## **RESPONSE TO REQUEST FOR INFORMATION: 90-102 REGENT STREET, REDFERN (SSD-10382)**

This correspondence has been prepared by Urbis on behalf of The Trust Company (Australia) Limited ATF Wee Hur Regent Trust (**Wee Hur**) and relates to the above State Significant Development Application (**SSDA**) at 90-102 Regent Street, Redfern.

It responds to a Request for Information (**RFI**) issued by the Department of Planning, Industry and Environment (**DPIE**) on 25 May 2021. DPIE requested a response to the additional submission by the City of Sydney following their review of the Revised Response to Submissions (**RRtS**) report submitted by Wee Hur on 27 April 2021.

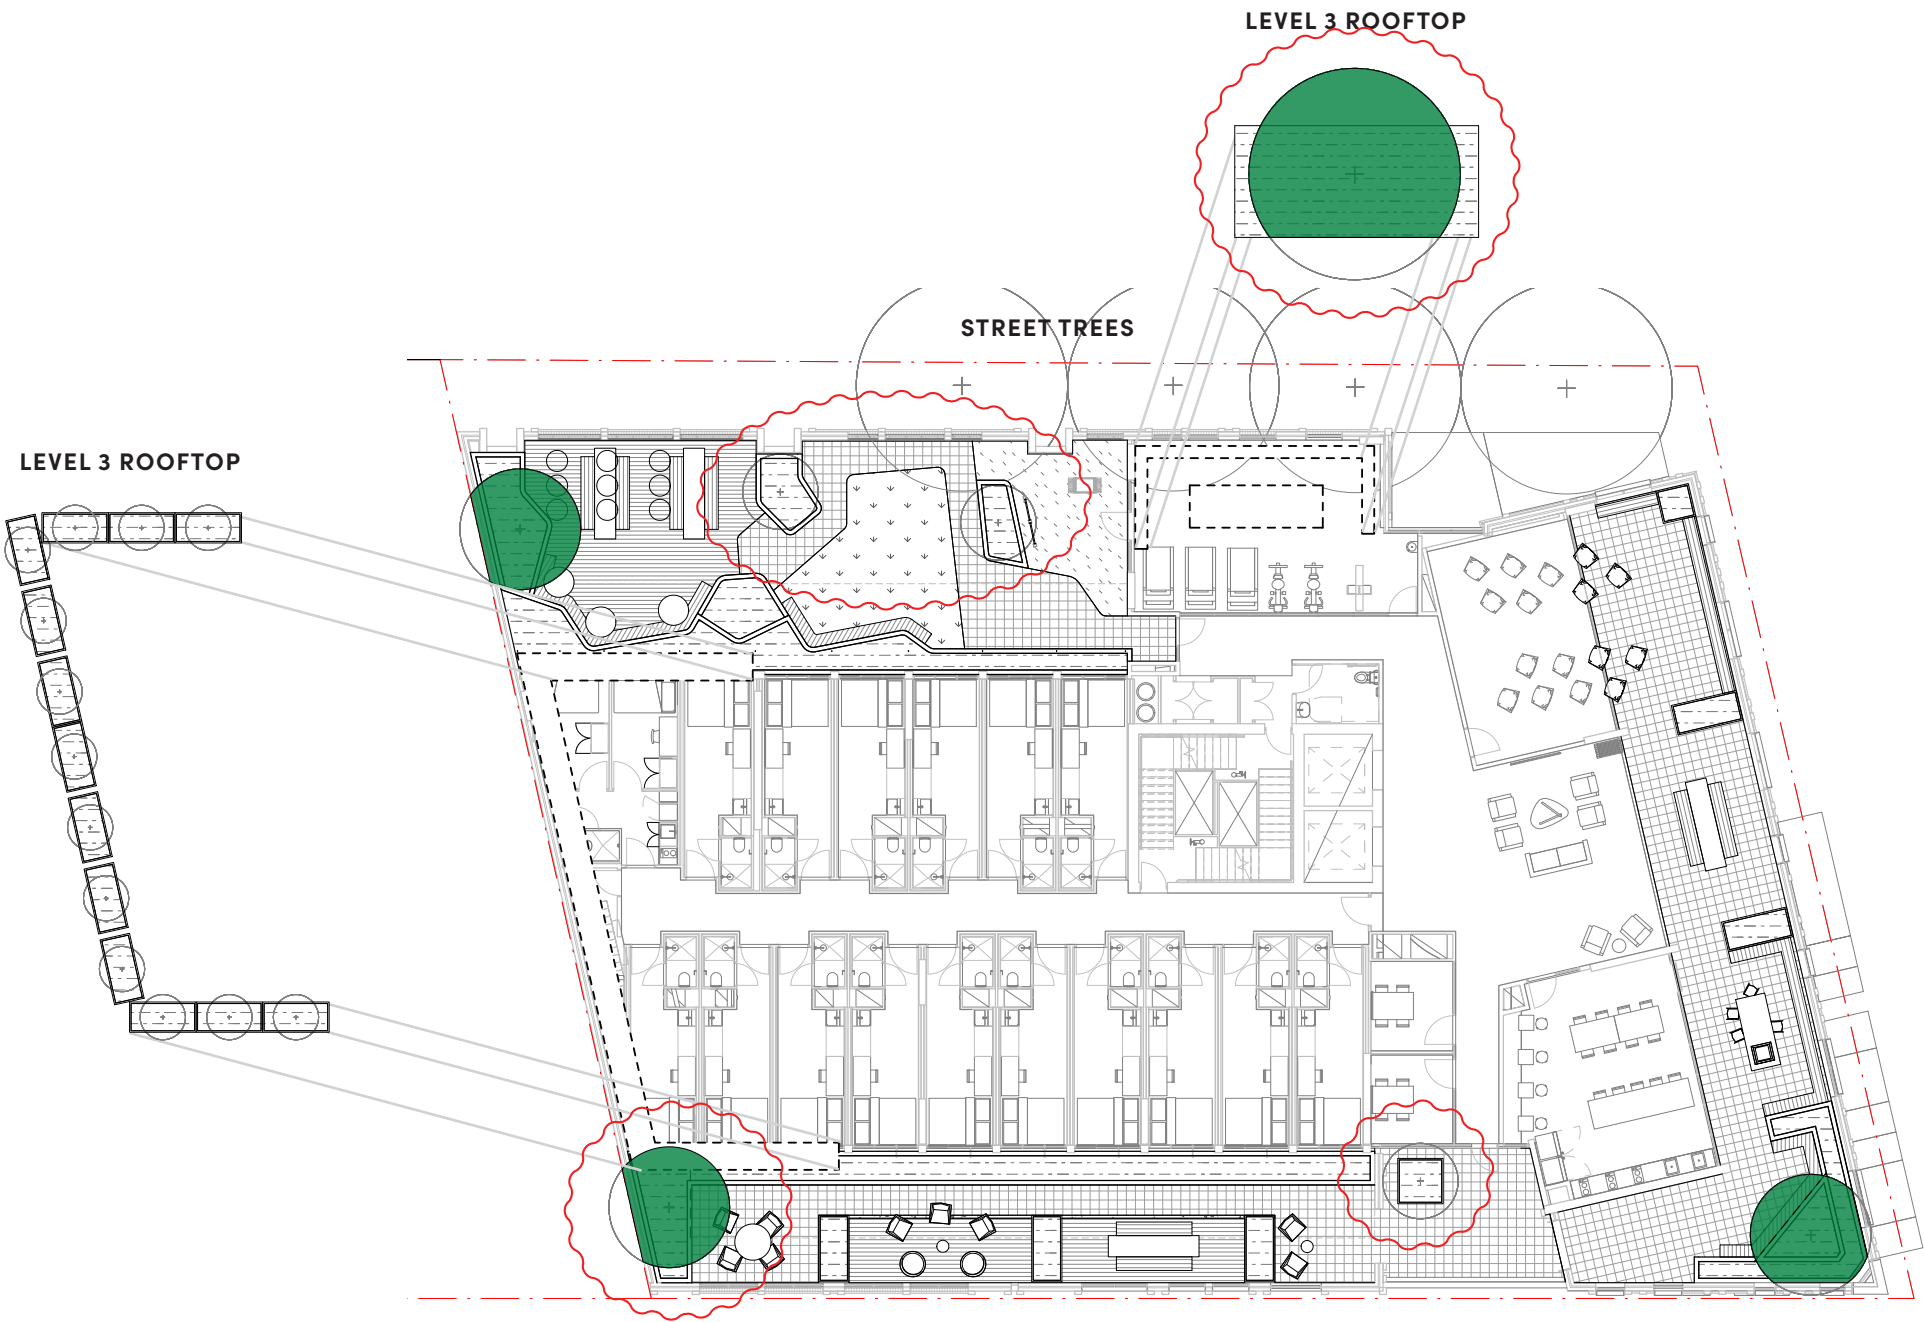
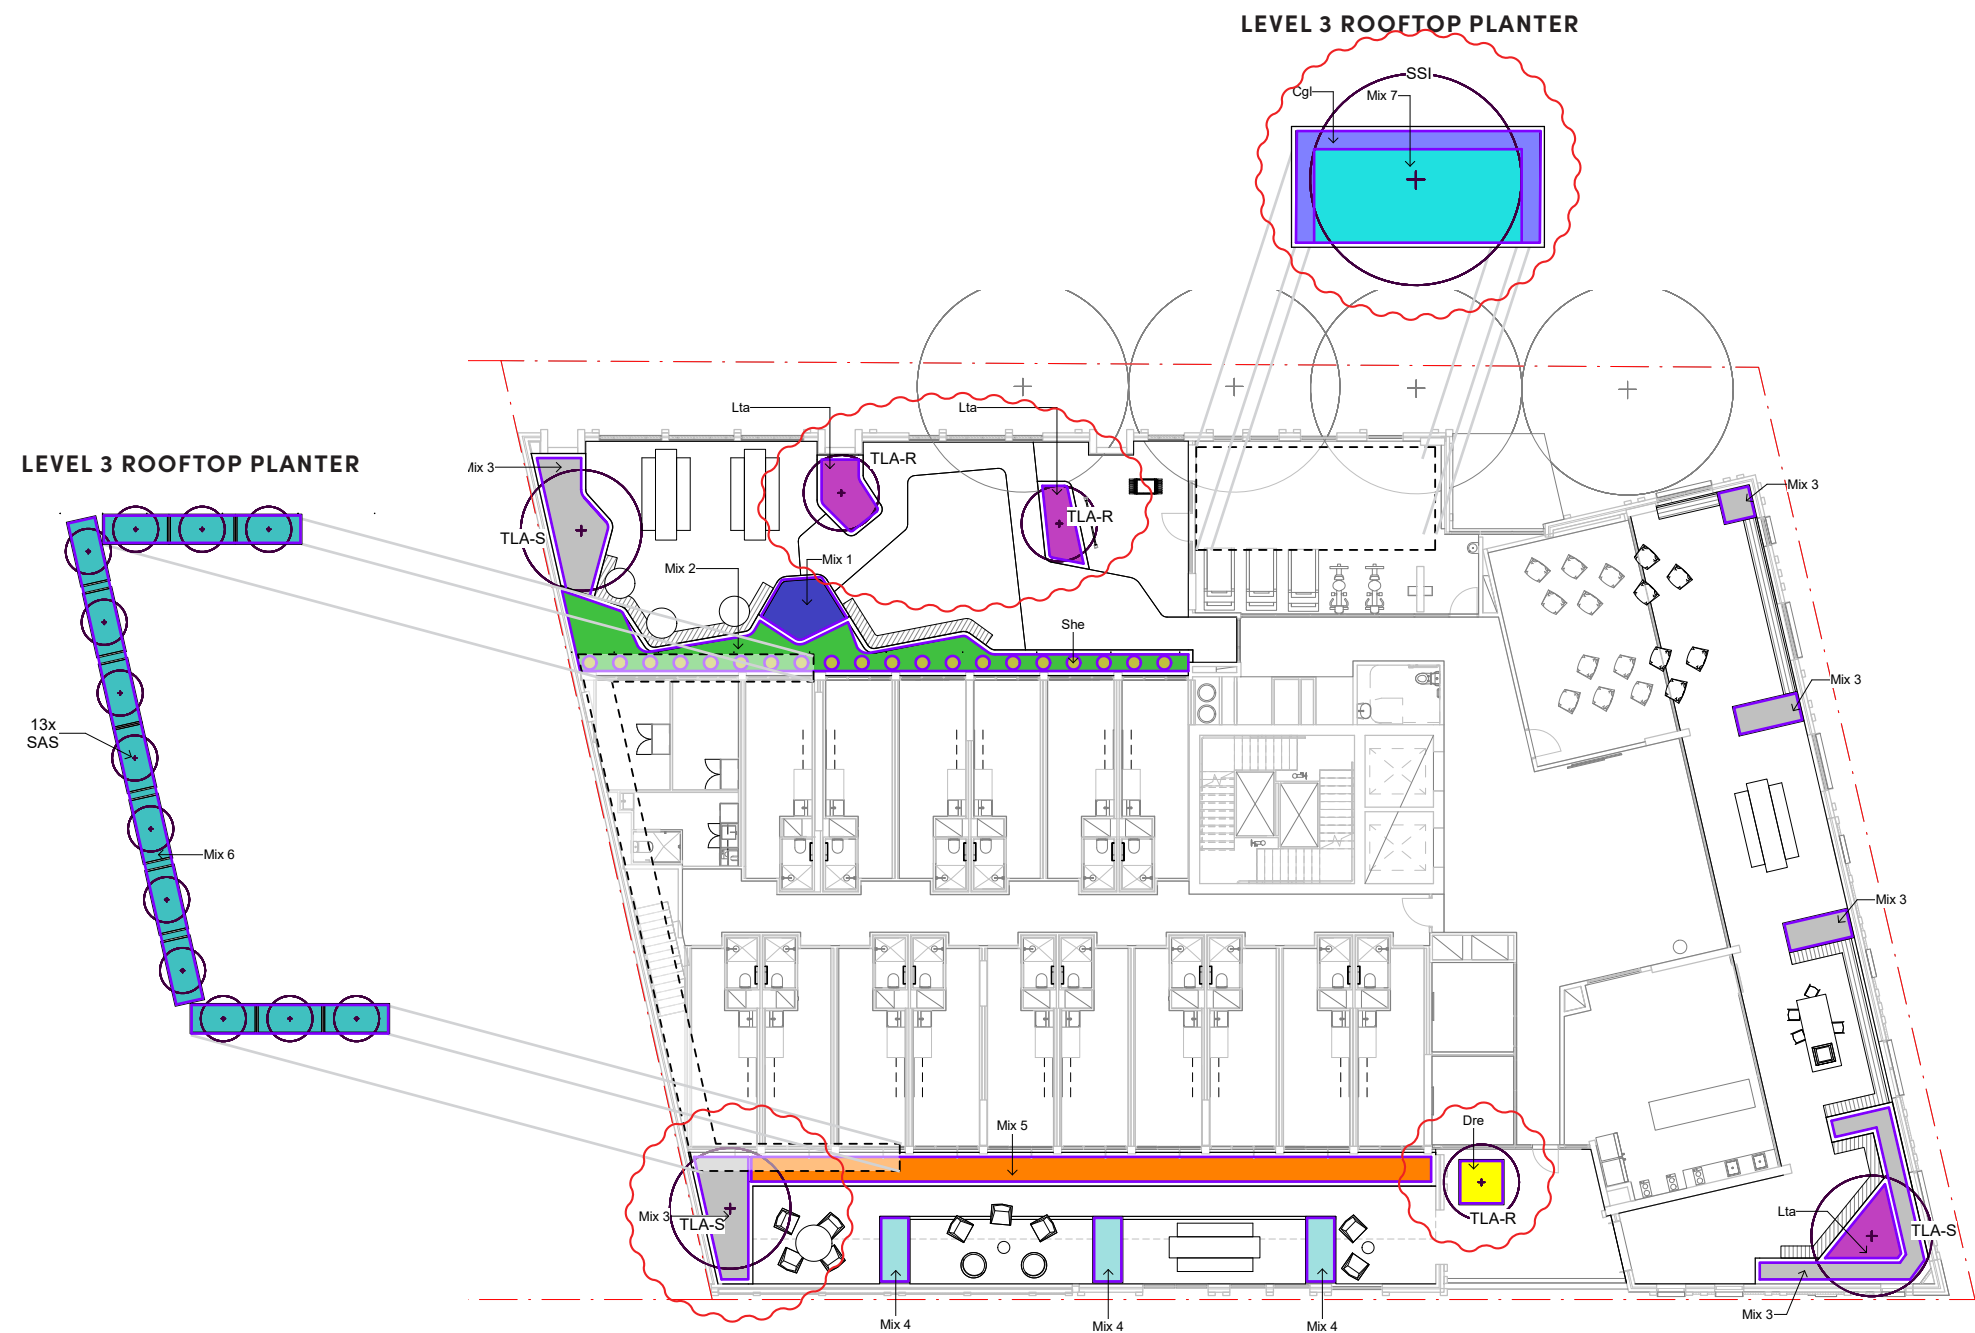
2a	<p><b>Landscaping</b></p> <p>Generally, there has been limited response to the previous concerns raised by the City in earlier iterations of this development. The proposed landscaping continues to be limited. The 15% canopy coverage requirement within 10 years of completion as prescribed under Sydney DCP 2012 will not be met. The canopy coverage from street trees within Council land does not count towards the canopy provided from the site. Specifically, the Syzygium 'aussie sothern' located on the level 3 roof top and the Tristaniopsis laurina are not of a size that would require their retention and protection under Sydney DCP 2012 and, therefore, do not contribute to the canopy cover of the site. The landscape plans must be amended to provide the required 15% canopy cover under the Sydney DCP 2012 controls.</p>	<p>The site is located within the Redfern-Waterloo Precinct under <i>State Environmental Planning Policy (State Significant Precincts) 2005 (the SSP SEPP)</i>. The SSP SEPP includes the land use zoning objectives, permissibility and built form controls relevant to the site and the proposed development. The site is not classified as land to which the Sydney Development Control Plan 2012 (<b>the DCP</b>) applies. Further, the provisions of a DCP do not apply to State significant development in accordance with Clause 11 of <i>State Environmental Planning Policy (State and Regional Development) 2011</i>.</p> <p>Based on the above, the 15% canopy coverage under Sydney DCP 2012 does not apply to the site or the proposal.</p> <p>Regardless of the above, the western terrace on Level 3 has been amended to</p>

Item	Issues	Action/ Response
		respond to the City of Sydney feedback on a merit basis, including the replacement of the three smaller trees with one medium tree (refer Item 2d for further detail). The proposed changes are detailed in the amended Landscape Plans ( <b>Appendix B</b> ). Further detailed justification for the proposed landscape treatment is provided in the response to City of Sydney comments prepared by Turf Design Studio ( <b>Appendix H</b> ).
2b	Based on the low-growing species listed in each relevant planter mix and the lack of detail on fenestration and screening in this location, this remains unconfirmed.	<p>The eastern terrace interface includes mid-level screening, (Cordyline stricta and Blechnum 'silver lady') and supplementary screening (Cordyline glauca).</p> <p>The western terrace interface includes climbing species along vertical wires. Additional mid-level shrub planting is proposed to supplement the original planting to increase visual screening. Cordyline stricta and glauca have been added to the updated Landscape Plans (<b>Appendix B</b>).</p>
